# Rosefield Solar Farm (EN010158)

**Rosefield Solar Farm – Buckinghamshire Council’s ISH1  
Post Hearing Note**

Buckinghamshire Council

May 2026

TITLE:
APPENDIX 5A
GREEN AND BLUE INFRASTRUCTURE PARAMETERS
BUFFER WIDTHS - KEY PLAN

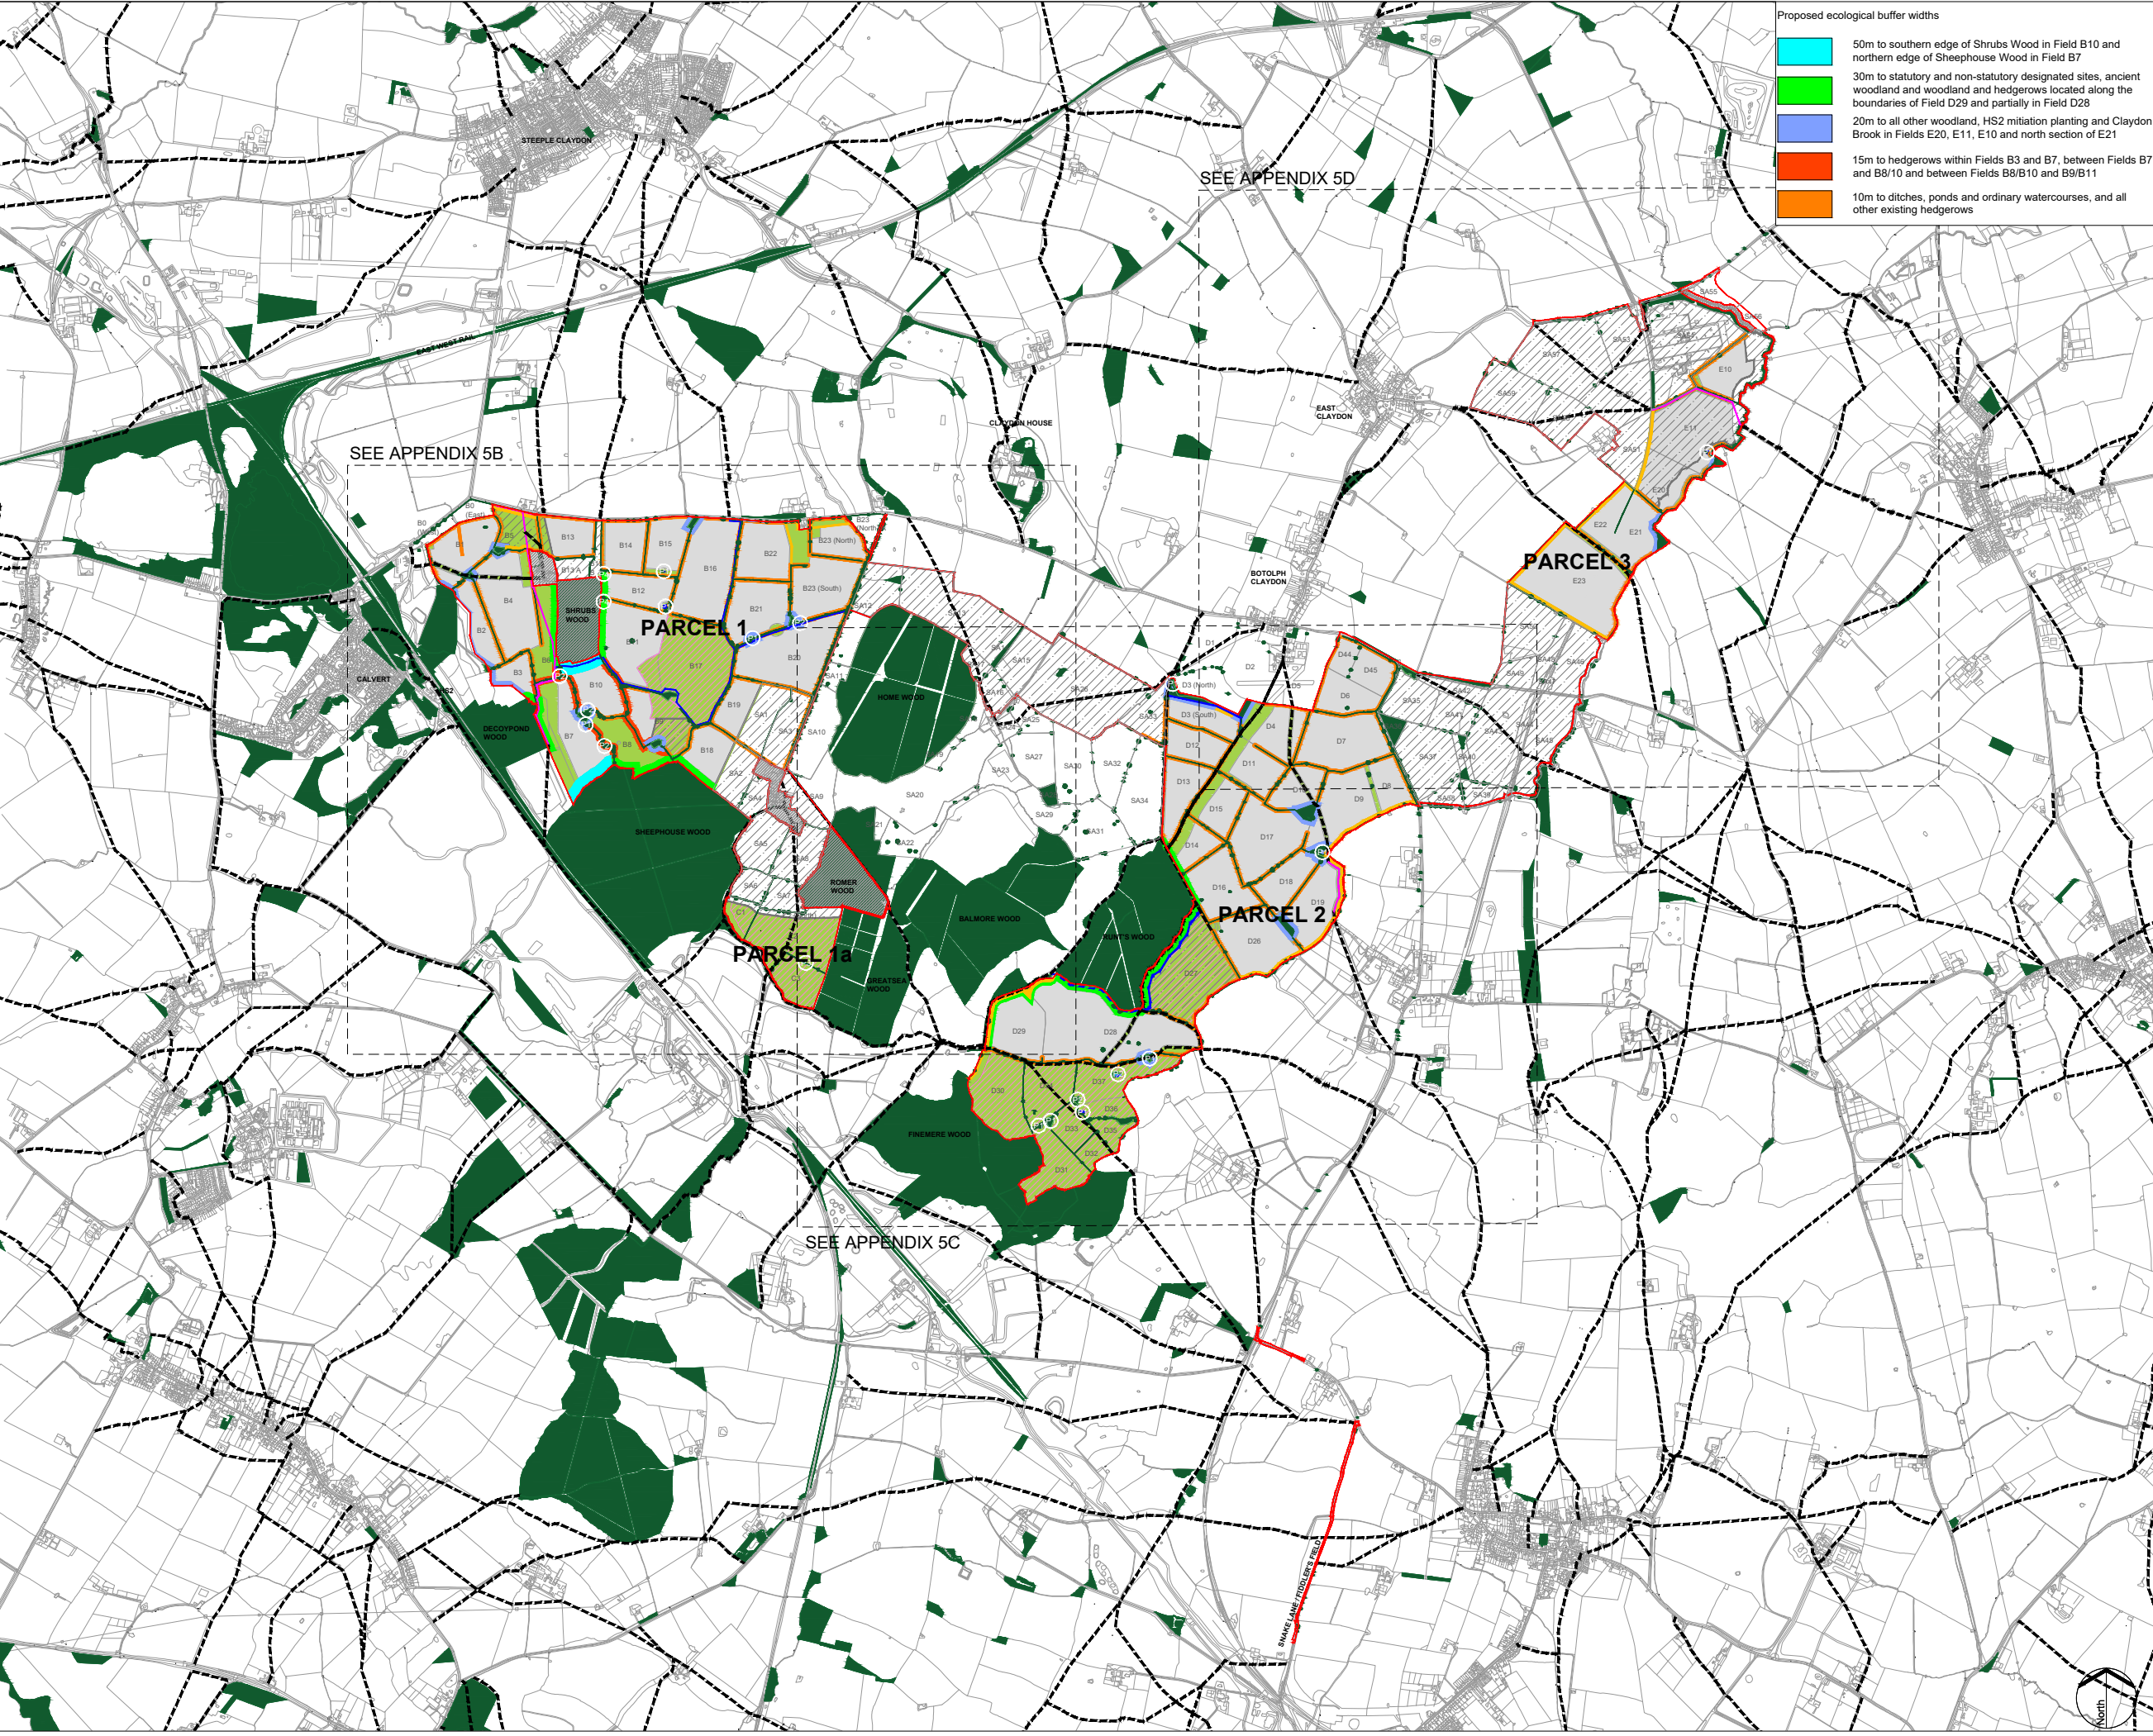
22. On buffers, Ms Ottaway identified that this overlapped with arboriculture issues. She noted that the Council's local planning policy expected buffers for hedgerows which were to be measured from the edge of the feature. It was considered that measuring from the centreline did not protect the feature itself, particularly noting that the hedgerows were old, wide, non-uniform and contained large trees.

23. The Council's position was that buffers measured from the centreline did not even protect the root protection areas of some large trees in many places. Ms Ottaway highlighted that, as a result, the Council did not consider the buffers sufficient for the bats, for the features themselves, or for wider ecological purposes. The
